**Re: Rio Grande Zoological Park Entry,
Request for Permanent C.O. - Approved
Engineer's Stamp dated: 11-09-10 (K-13/D034C)
Certification dated: 10-24-11**

Re: City Zoo Entry
Grading and Drainage Plan
Engineer's Stamp dated 11-09-10 (K13/D034C)

RE: Rio Grande Zoo Entry (K13/ D34C)

Re: City Zoo Entry
Grading and Drainage Plan
Engineer's Stamp dated 11-02-10 (K13/D034C)

CITY OF ALBUQUERQUE PUBLIC WORKS DEPARTMENT ENGINEERING GROUP		NOV 09 2010 HYDROLOGY SECTION	
TITLE: CITY OF ALBUQUERQUE ZOO GRADING AND DRAINAGE PLAN			
Design Review Committee	City Engineer Approval	Mo./Day/Yr.	Mo./Day/Yr.
City Project No. 730701	Zone Map No. K-13	Sheet C-1.0	Of

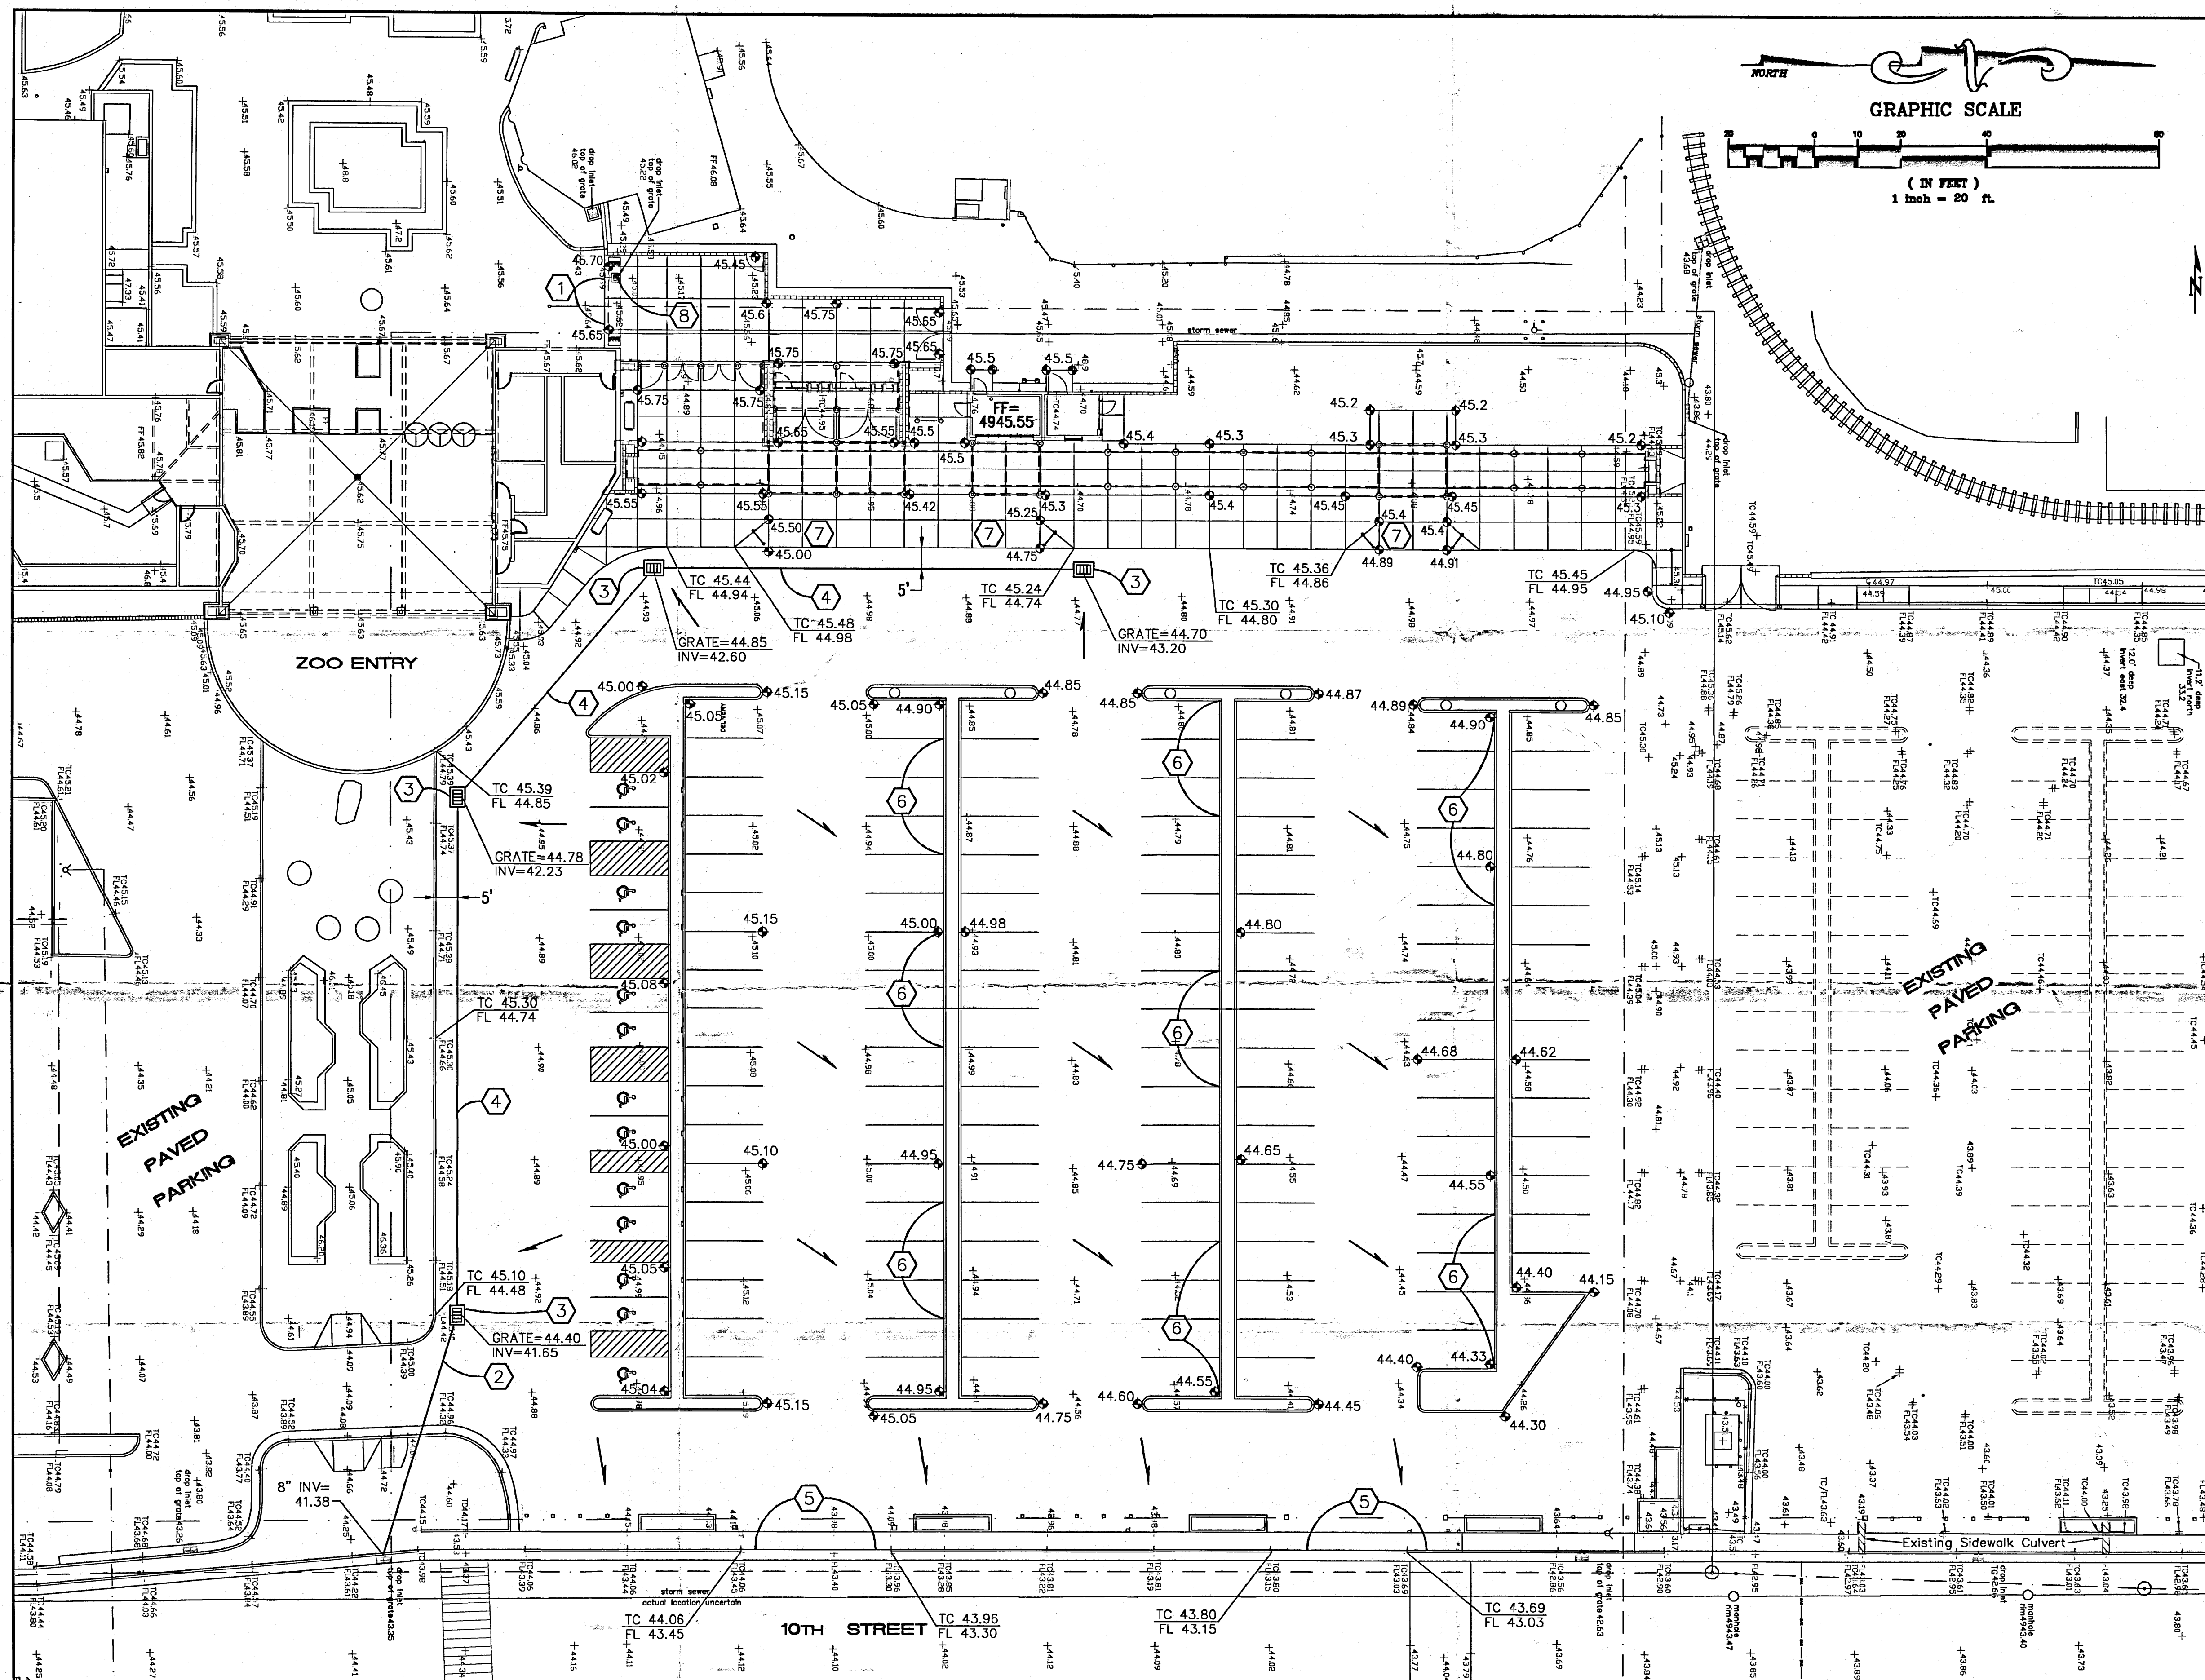
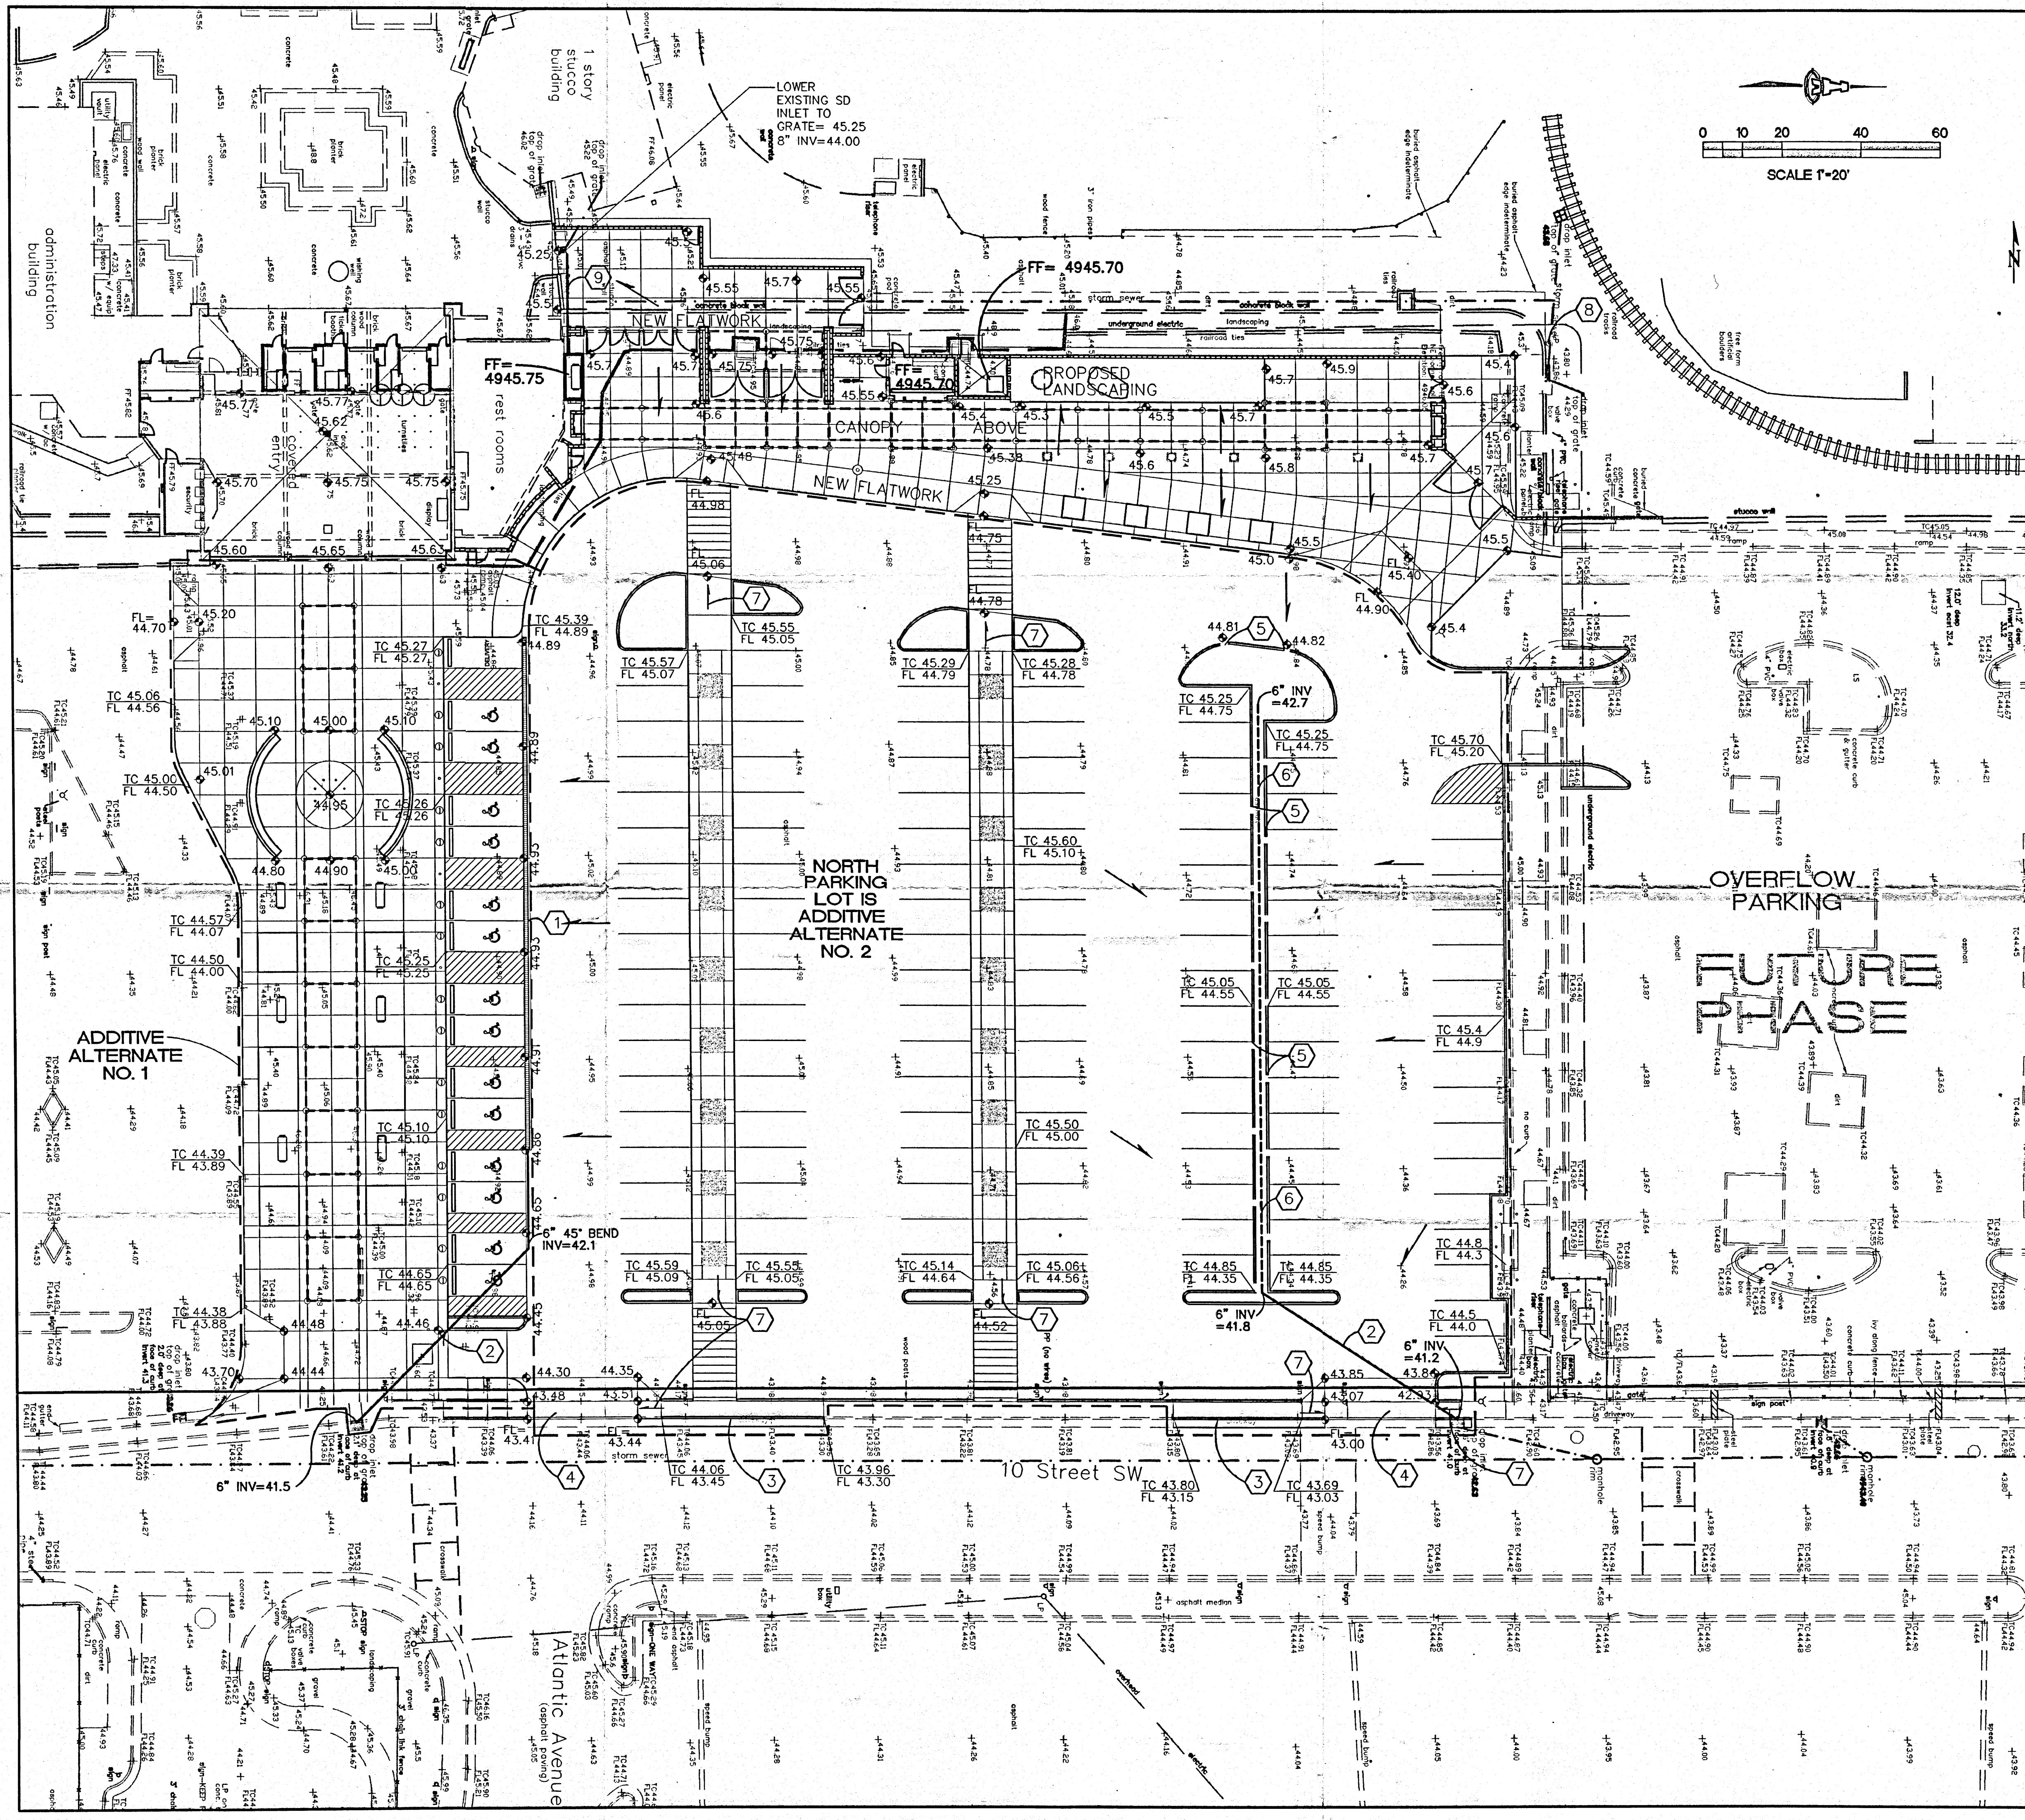
- Provide drainage calculations and directional Flows.
- The discharge line through the back of the inlet requires an SO 19 permit.
- Provide a narrative of this site. What is the flood zone, etc.?
- Is this existing pavement, repaved or new pavement?
- What is the hatched area in the N.E. corner?
- Landscaped areas between curbs should be depressed.

Drainage calculations, directional flow arrows, and a narrative have been added to the plan. The standard right-of-way construction notes for an SO 19 have been added. All of the parking lot paving shown is existing. The sidewalk culverts shown along the west side of 10th Street are also existing. All parking lot medians are existing and have mature landscaping. The curb cuts proposed are located in areas where the landscaping can be depressed and not negatively impact the landscaping.
